Application number: 2023/92966	
What is the application for?:	Demolition of existing dwelling and erection of 87 dwellings including formation
Address of the site or building:	Land to the rear of, 271, Cliffe Lane, Gomersal, Cleckheaton, BD19 4SB
Postcode:

Type of comment: A general comment	
Do you wish your comments to be published on the website anonymously?	Yes
<p>I wish to make a comment with reference to the hedge on the eastern end of the site, namely hedge H1 as identified in the report from Elliott Consultancy arboricultural consultants.</p> <p>This report lists hedge H1 as being a hedge to be retained in the development and states details as to how the hedgerow and its bird inhabitants should be protected during construction.</p> <p>I am concerned that the many plans which have been produced for the application have a varied clarity of detail regarding this hedge and through misinterpretation at some point there could be a danger of the hedge being removed.</p> <p>For example, I have concerns about the term 'hedge line' which is used extensively throughout the plans. This term is open to misinterpretation. A hedge line could be a line where a new row of hedging plants is

CLIENT	QUARTERS GOMERSAL
PROJECT	CLIFFE LANE, GOMERSAL
TITLE	SITE PLAN LAYOUT
DRAWING NO.	1694-101
REVISION	F
SCALE	1:500 @ A1
DATE	01.23
DRAWN BY	BC
CHECKED BY	-

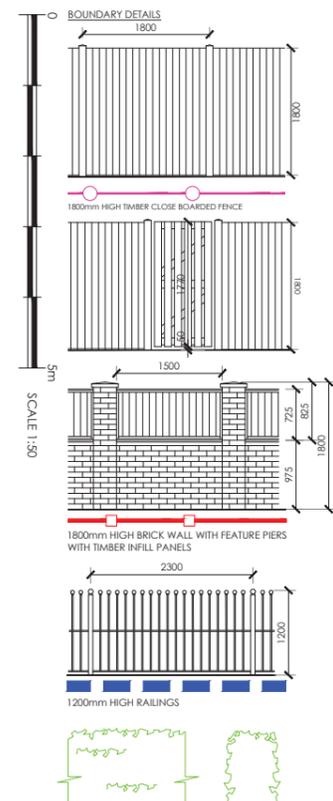
Similarly, please see Block Plan ID. 1044258. Site Plan Layout. This has a key which shows that a blue line surrounds any 'Existing trees /shrubs / hedges to be retained'. Where hedge H1 should be there is no hedge nor blue retaining line.

I ask that all plans should be checked and where necessary revised so that the term 'hedge line' is removed and the more appropriate annotation 'hedgerow to be retained' is used. I hope this will avoid any misinterpretation.
